Q No.	To:	Question	Response
1.0.4	SCC	Development Plan a) Could SCC please provide all minerals and waste plans applicable to the Application site along with any relevant plans necessary for interpretation. b) Are any of these plans subject to review? c) If so, at what stage has it/have they reached? d) Does this have any implications for the Proposed Development?	<p>a) Please see links below to:  <a href="#">The Staffordshire and Stoke-on-Trent Joint Waste Local Plan (2010 – 2026)</a>; and  <a href="#">The Minerals Local Plan for Staffordshire (2015 – 2030)</a> – adopted 16/2/17</p> <p>b) No updates to the above Plans have been identified as yet so there are no programmes for Plan review.</p> <p>c) n/a</p> <p>d) n/a</p>

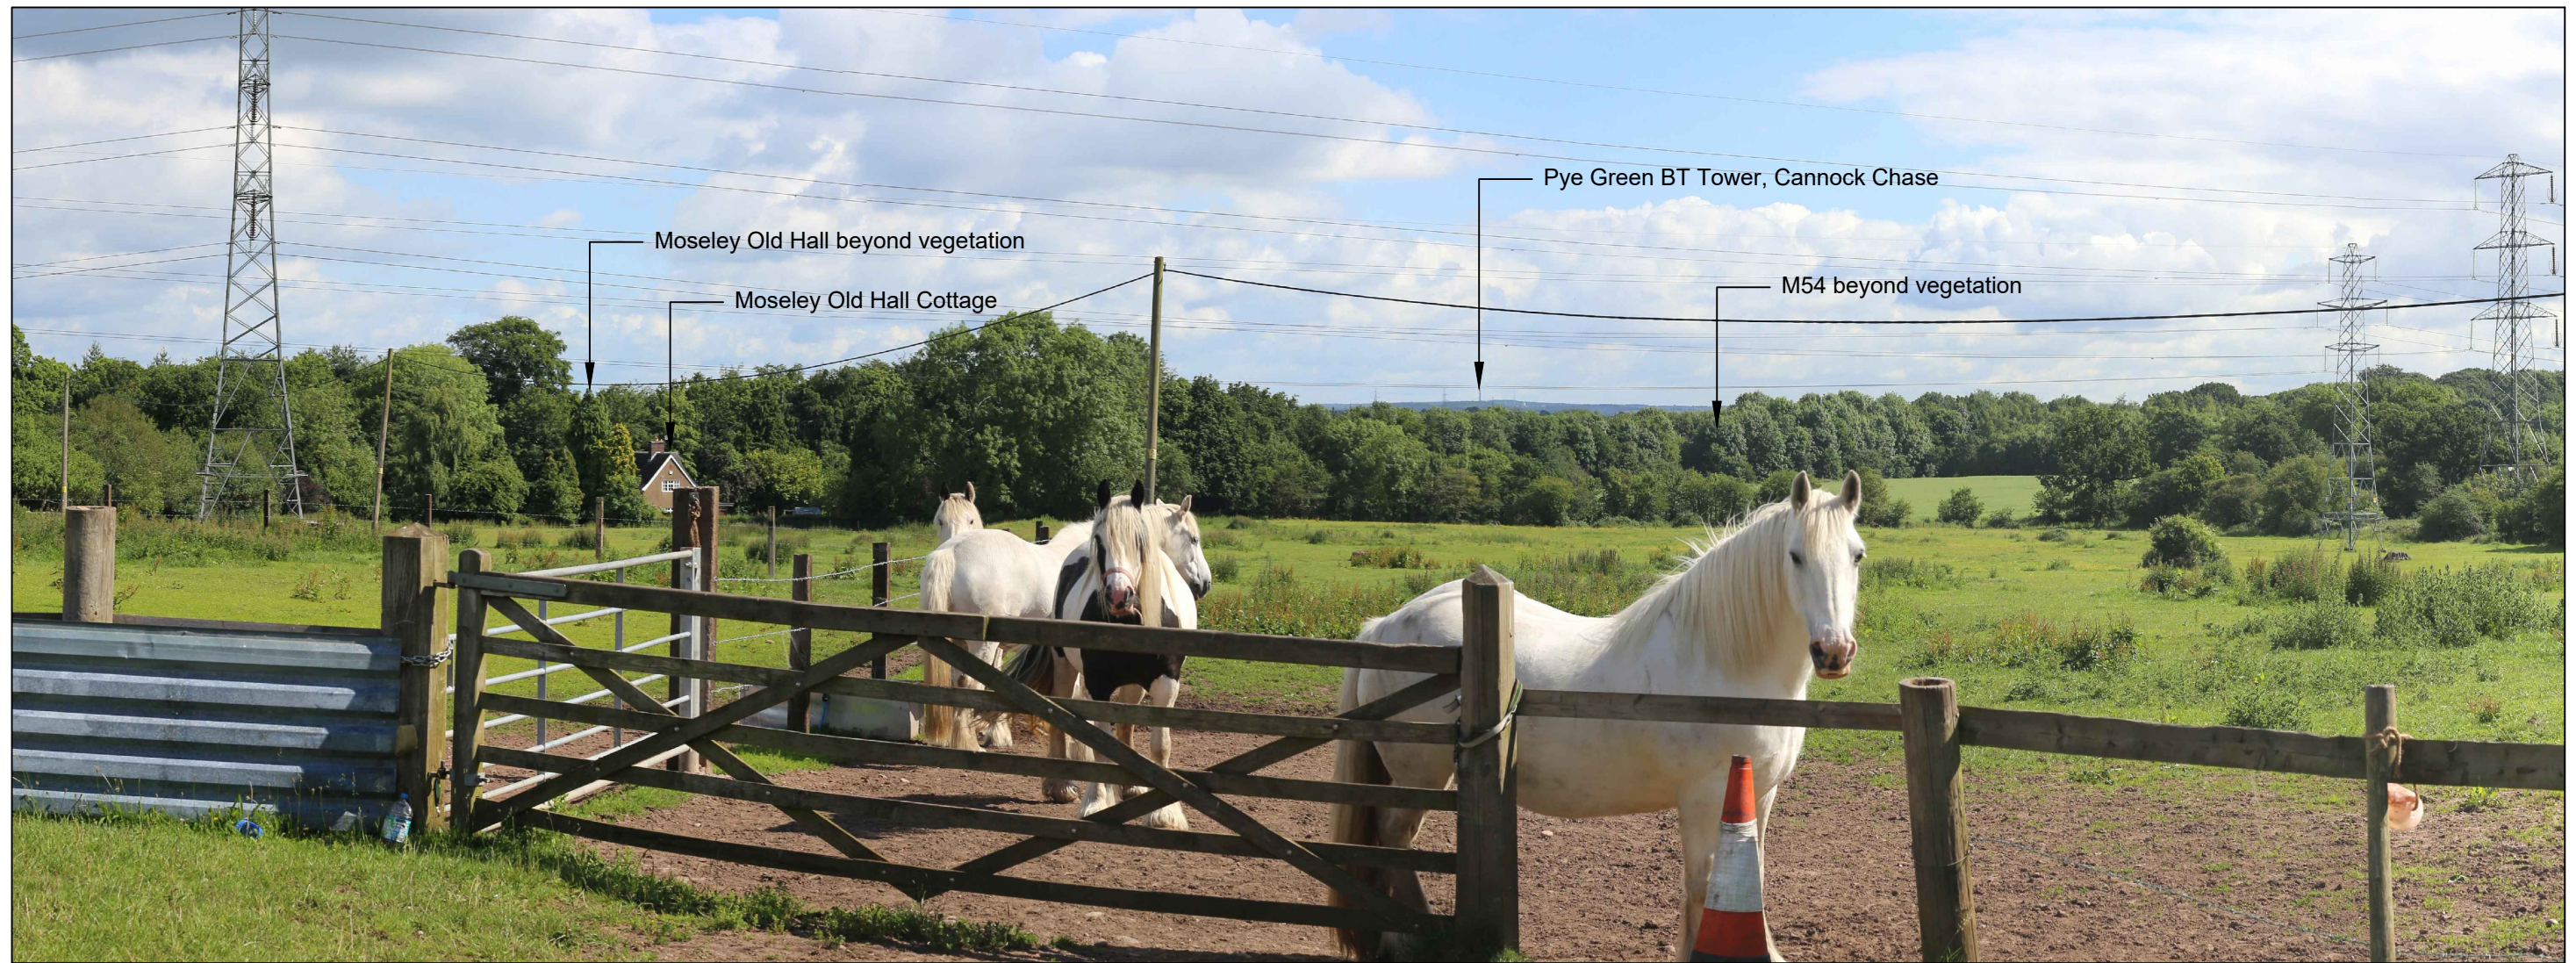
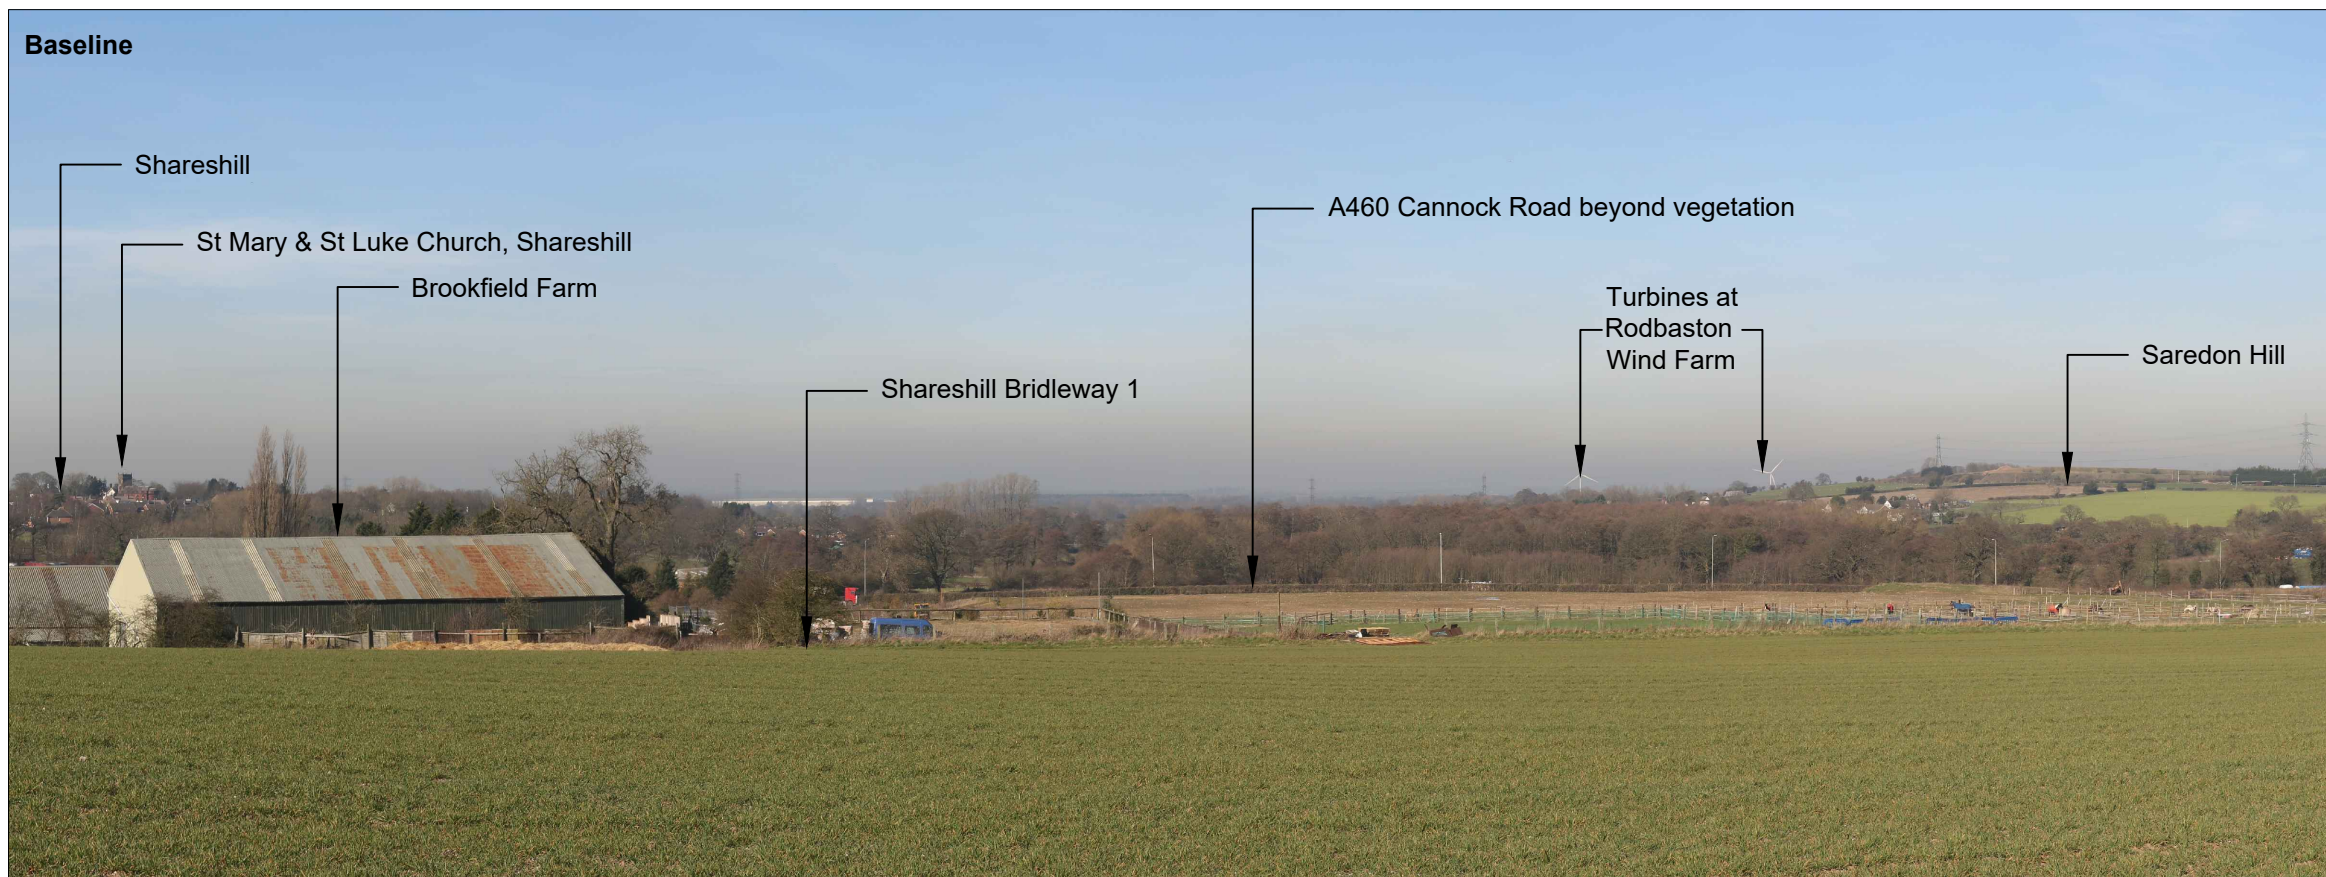
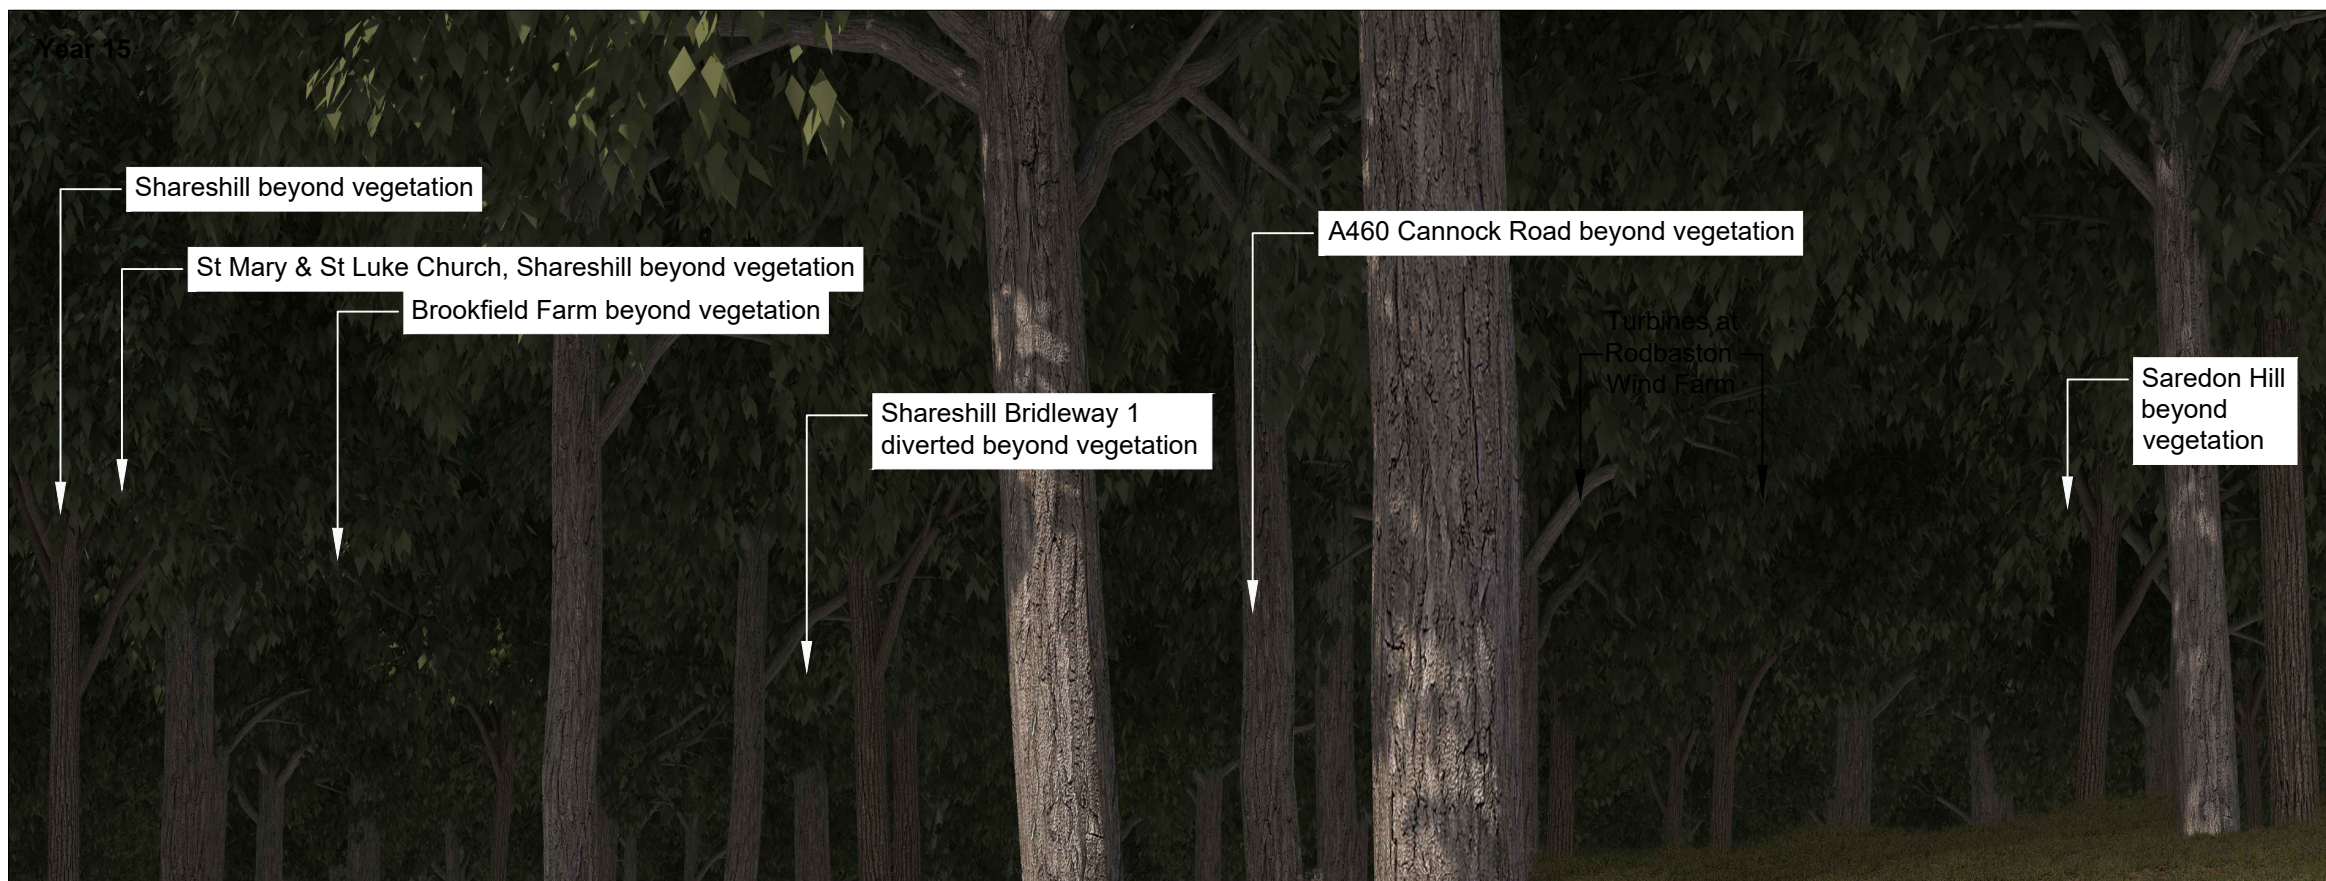
1.7.7.	SSC SCC Interested Parties	Representative viewpoints a) The Applicant has set out a series of viewpoints in Figures 7.5 to 7.25 [APP-088 to APP-108] which it sees as representative. Do the parties consider that any additional viewpoints, not covered by the representative viewpoints, should be considered? b) If so, please provide details of the additional viewpoint(s), preferably on an Ordnance Survey base, explain why that viewpoint has not been already represented by one of the existing viewpoints and why it is important. It may be that rather than produce photographs the ExA may be able to visit the viewpoint as part of one of the Site Inspections	The viewpoints are representative and they cover the whole study area. As discussed in 1.7.6 above there may be locally valued viewpoints as highlighted by the local community which have not been considered to date. Detailed design should review any community representations on landscape views and attempt to address and mitigate the impacts.
